City of Albuquerque

December 20, 1988

RE: GRADING/PAVING FOR EL BUEN SAMARITANO UNITED METHODIST CHURCH
(J-14/D76) ENGINEER'S STAMP DATED DECEMBER 12, 1988

GRADING AND DRAINAGE PLAN
FOR NEW PARKING LOT
EL BUEN SAMARITANO
UNITED METHODIST CHURCH
(7TH STREET N.W. & GRANITE AVENUE N.W.)
ALBUQUERQUE, NEW MEXICO
DECEMBER, 1988

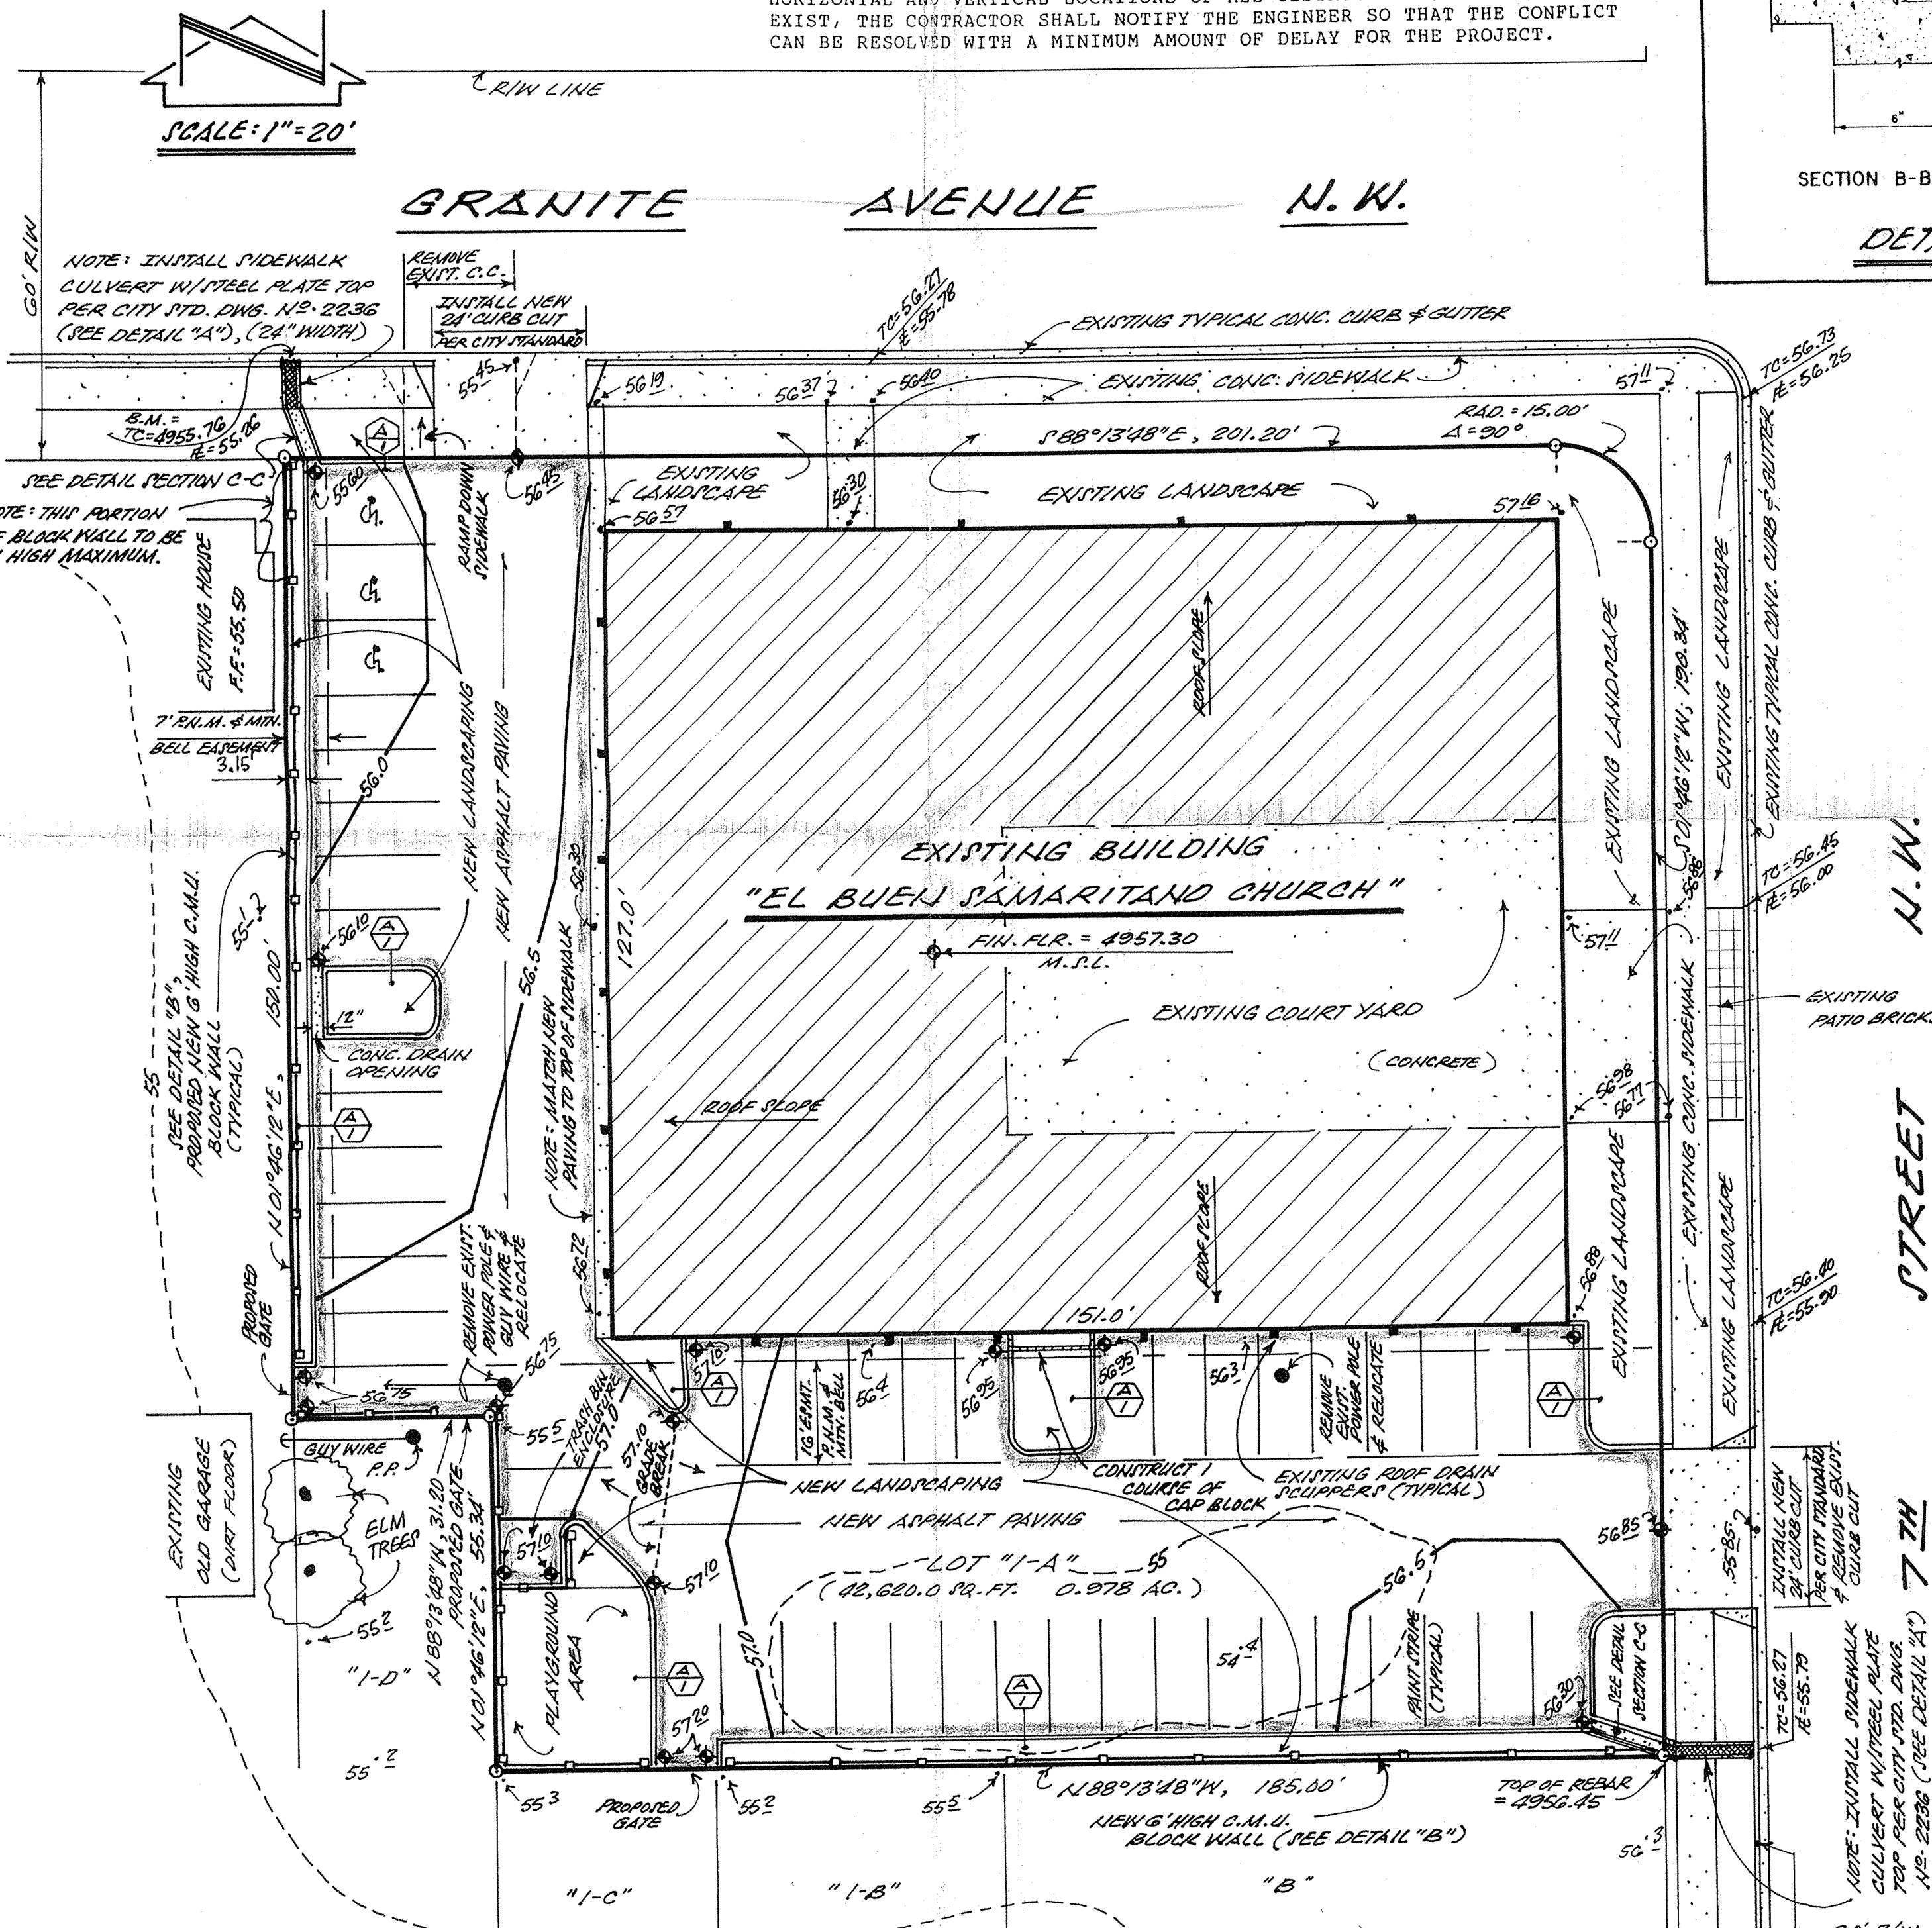
I have contacted Richard Dinson (Planning Department) and Victoria Prinz (Development Division) to inquire as to the meaning of the access provisions required by E.P.C. for Lot 1-C, 1-D, and Lot 4-A. They have advised me that they are considered for pedestrian traffic and not vehicular traffic. It would be advisable to consider installing railroad steps at each location for easy access onto the church parking area.
